Our ref: Waste Management Facility, Botany (SSD-62855708)

Subject: Request for Information in Submissions Report

Waste Management Facility, Botany Request for Further Information

Figure 6: Truck Routes

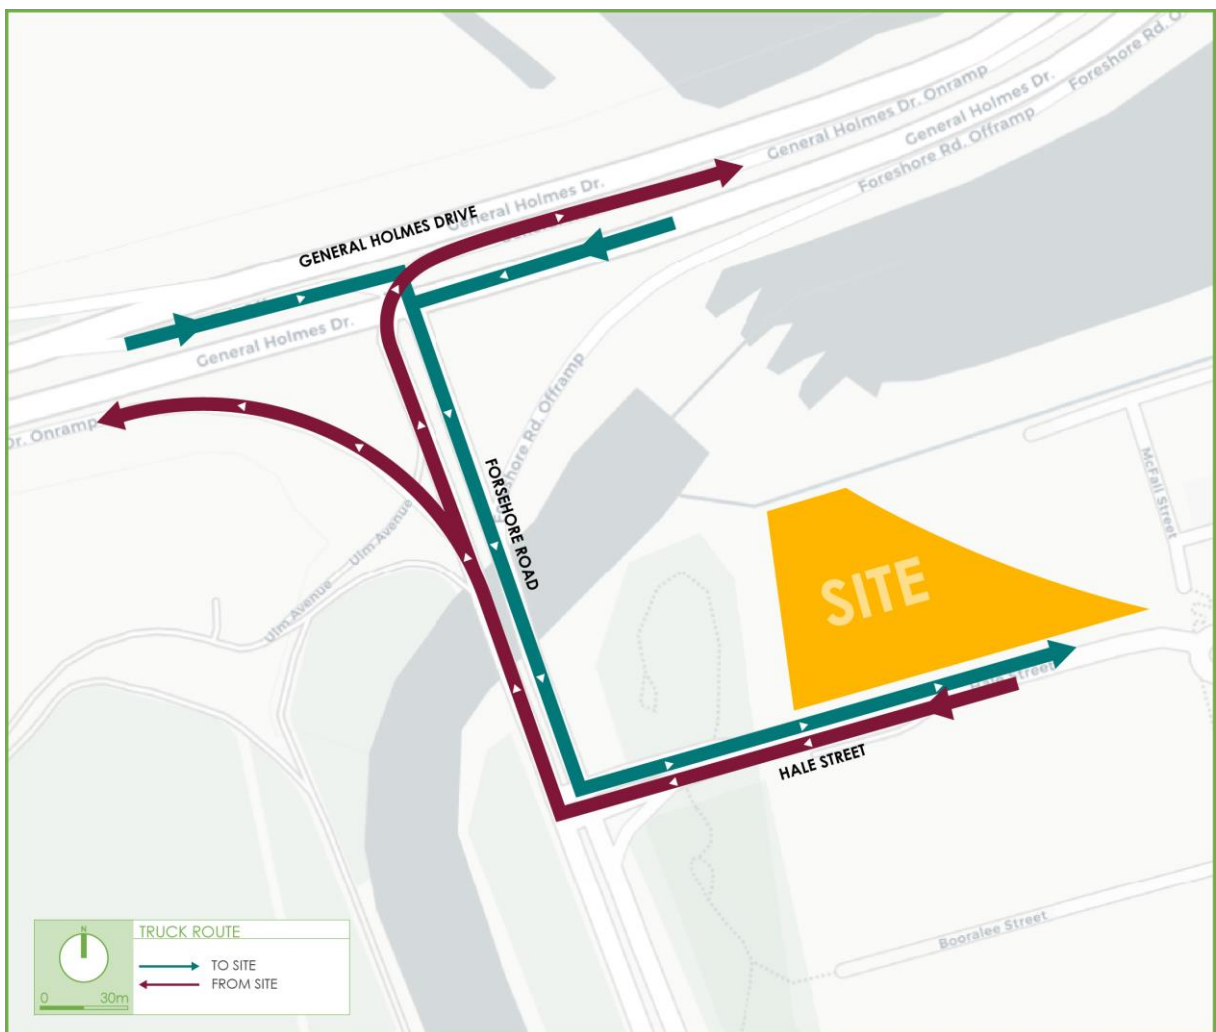
While B-doubles are limited to accessing the site from Foreshore Road based on NHVR B-double approved routes, there does not appear to be any restriction for smaller trucks accessing the site from Botany Road and then traveling west along Hale Street to the site access. It is not clear how smaller trucks will be prevented from turning right from Hale Street into the access driveway. This movement has the potential to obstruct through traffic travelling West on Hale Street.

Recommendation: Additional details of how operational traffic will be managed to prevent right-hand turns from Hale Street and how on-site truck movements will be managed in the event of vehicle queues near the site access, is required.

Swept Path Analysis
26m B-Double and 12.5m HRV
On-site Queuing
Incoming: One (1) B-double & Three (3) HRVs
Outgoing: One (1) B-double & Three (3) HRVs

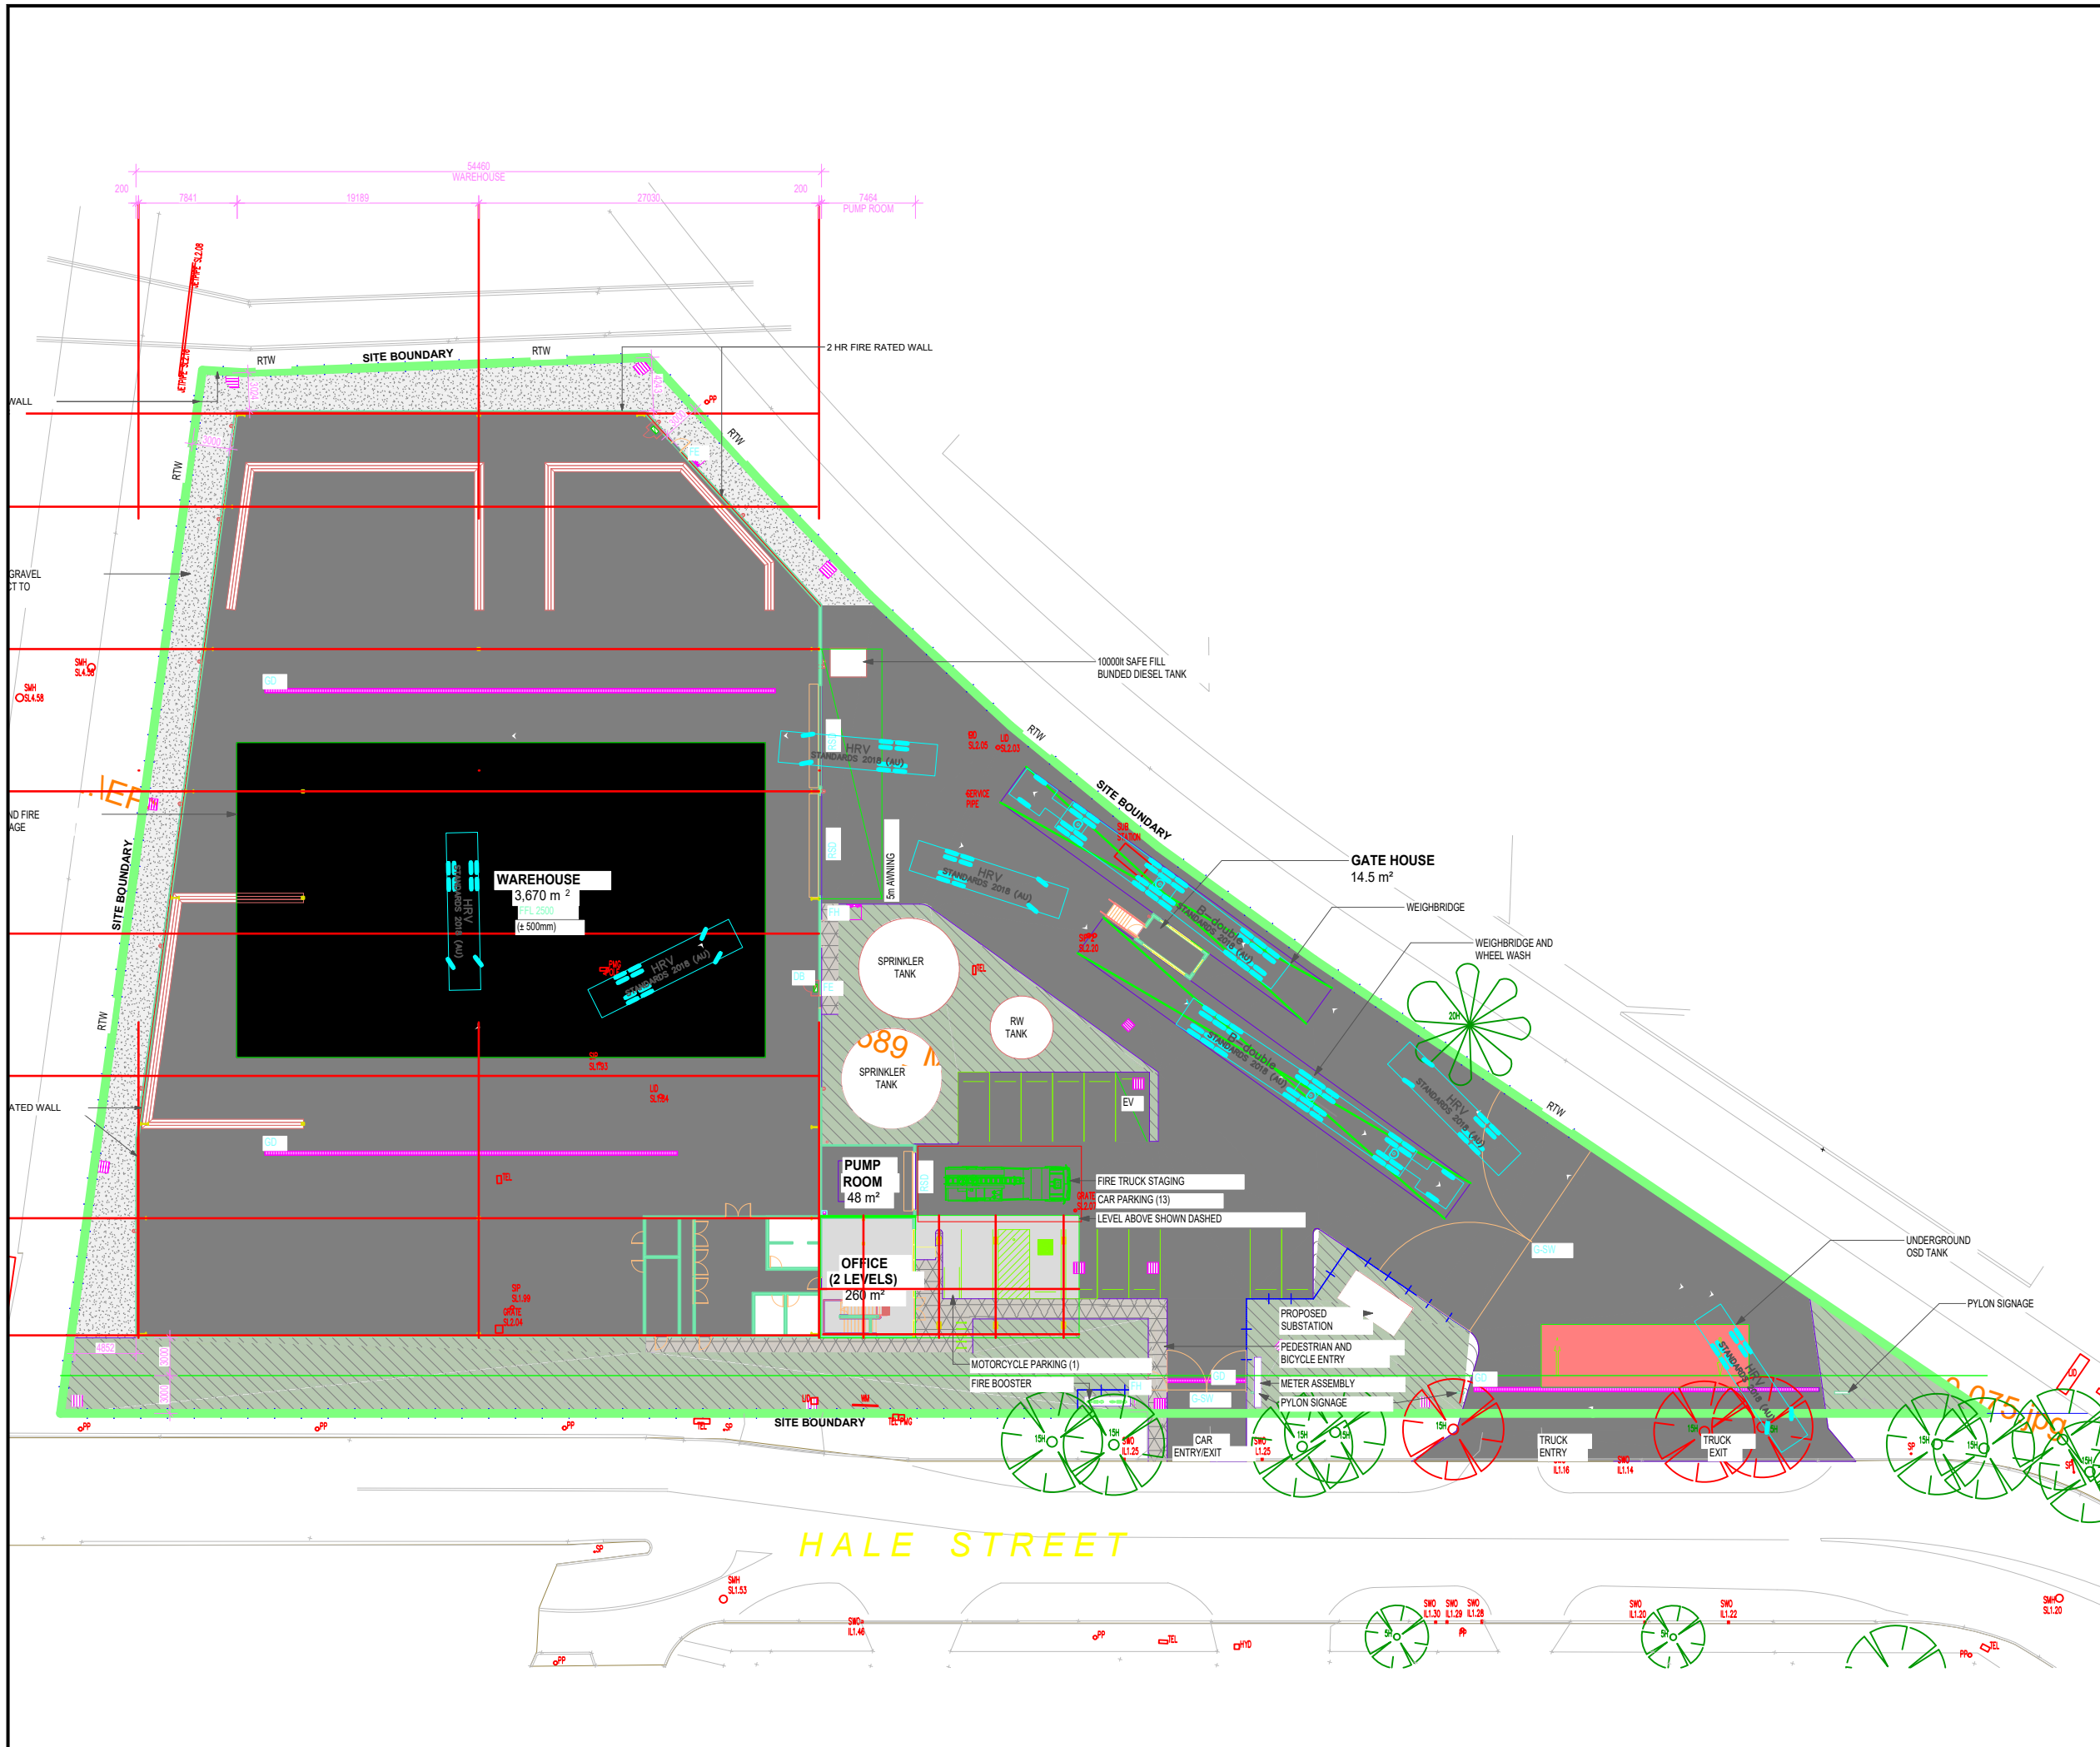
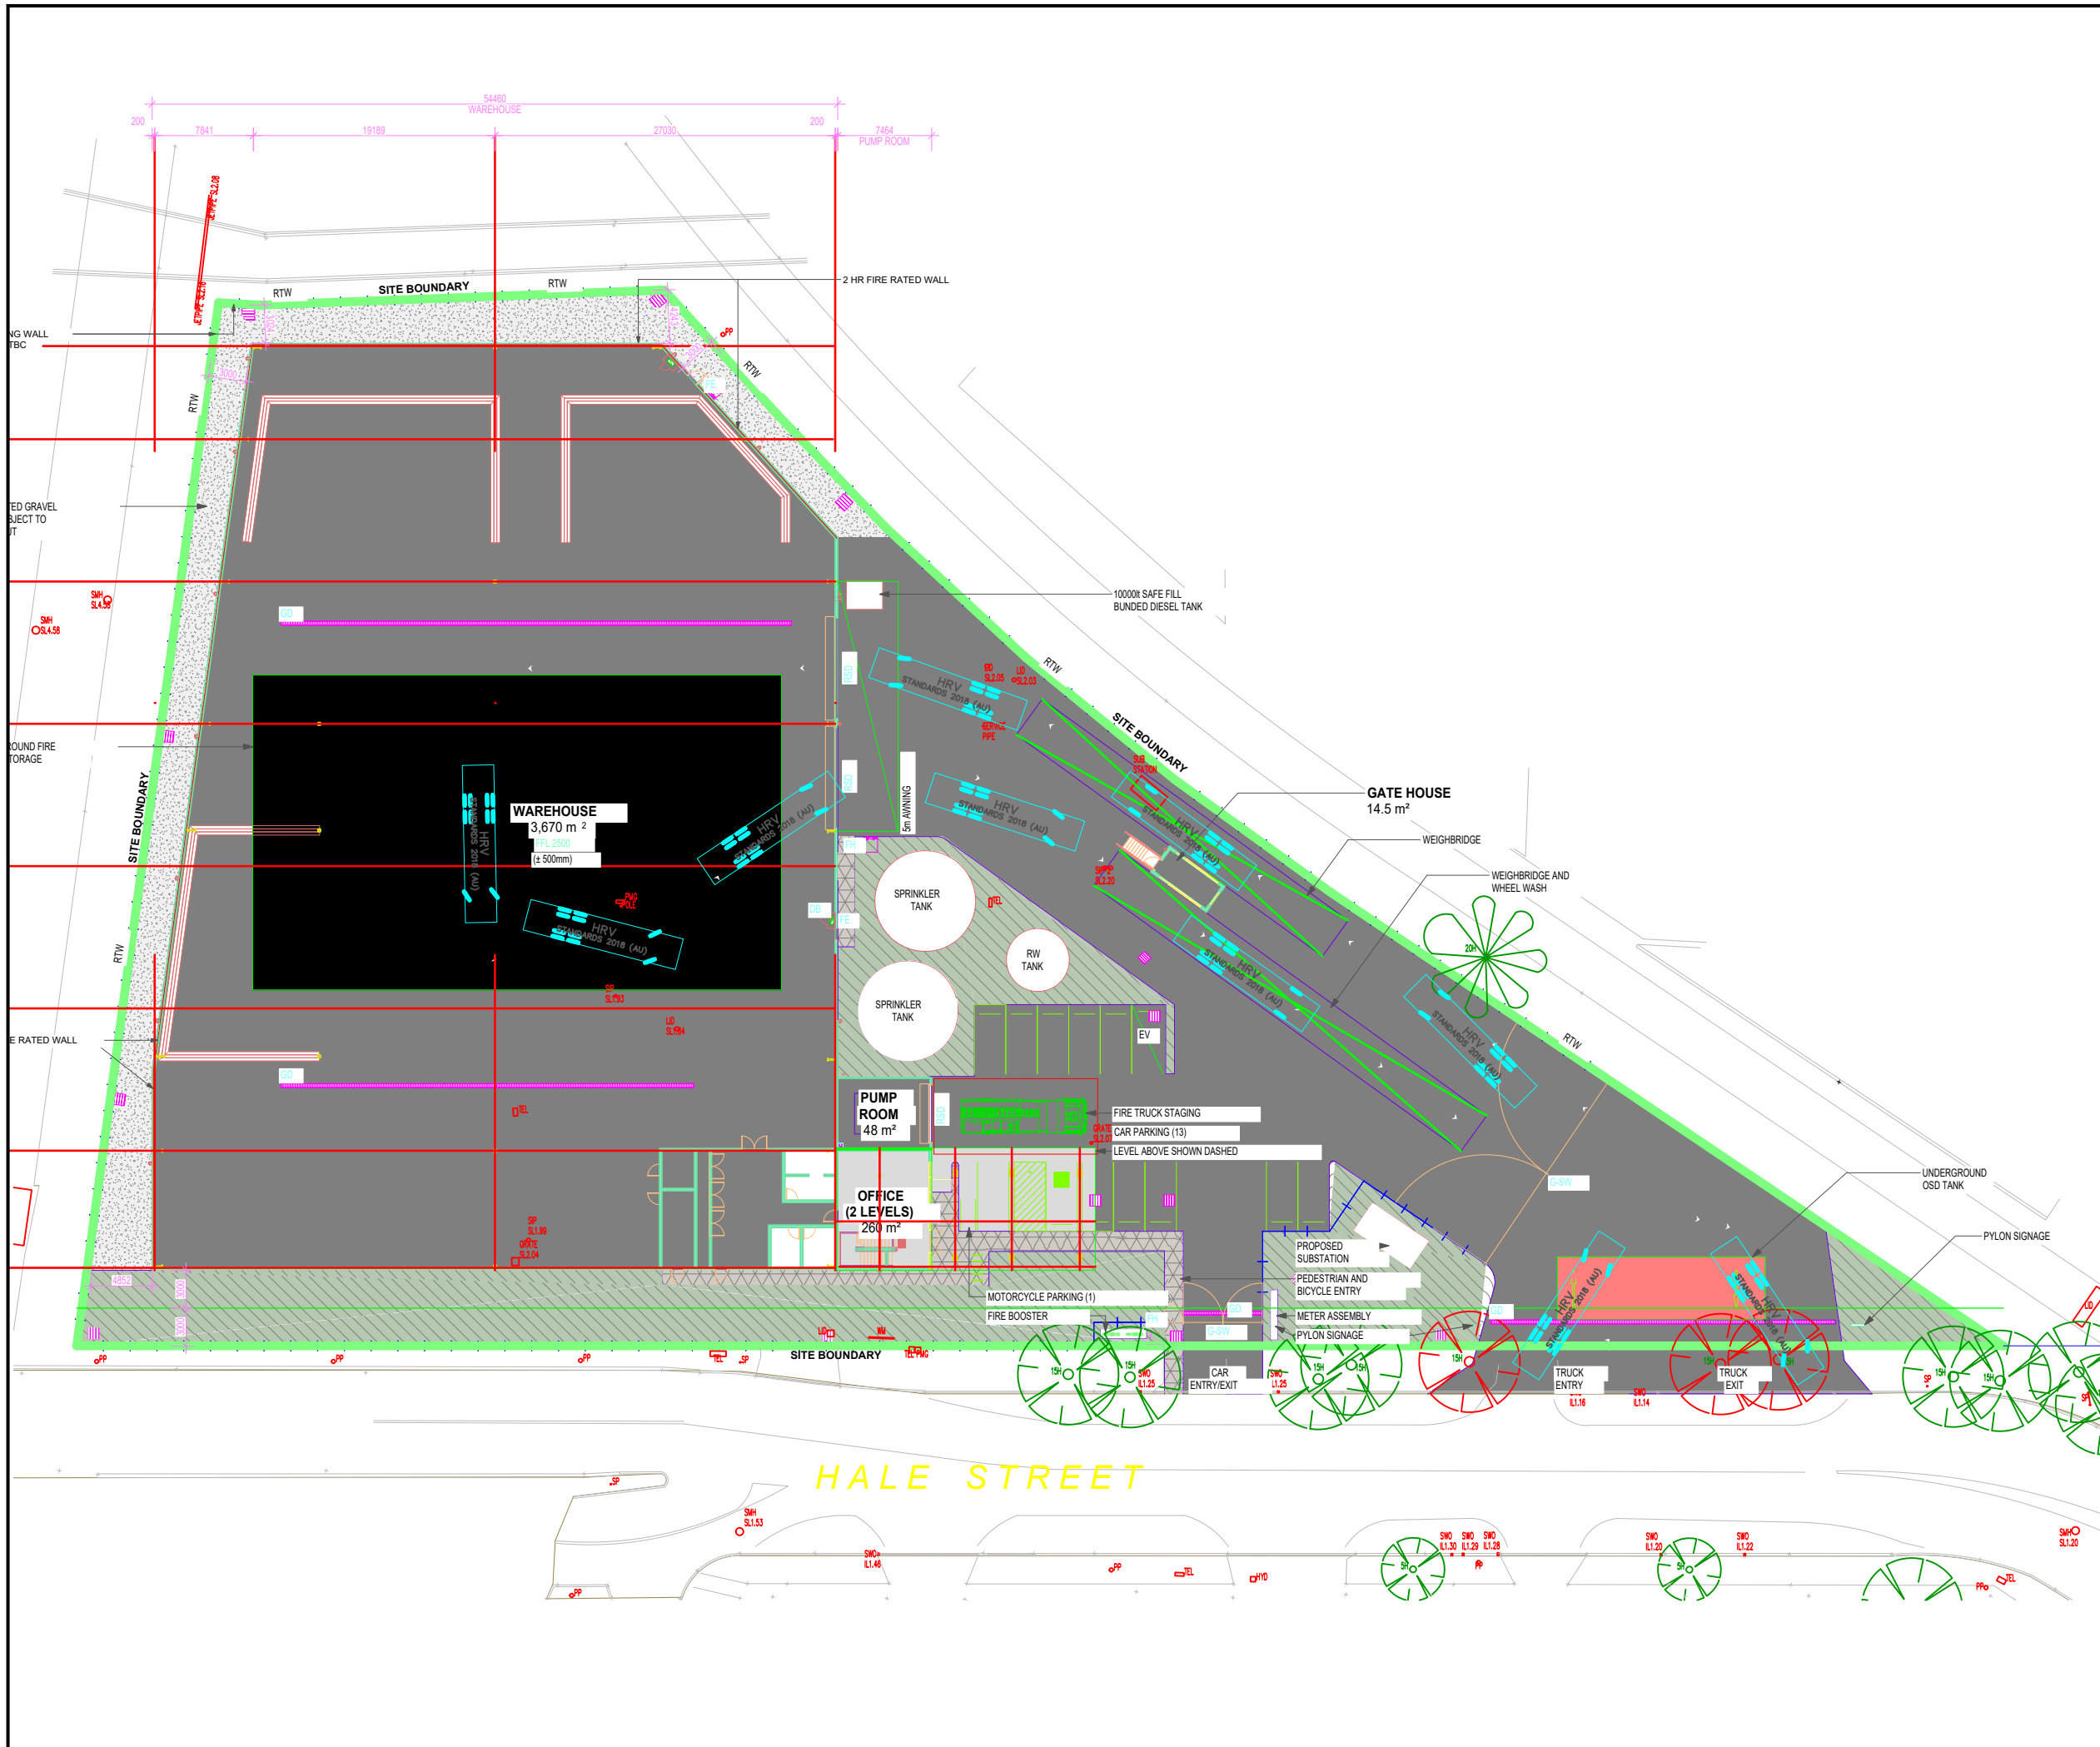
Section 6.12 Queuing of the TIA states that on-site staff will be trained to re-direct trucks should vehicle queues extend near the site access on Hale Street. Insufficient information has been provided to demonstrate the movements of re-directed trucks on-site.
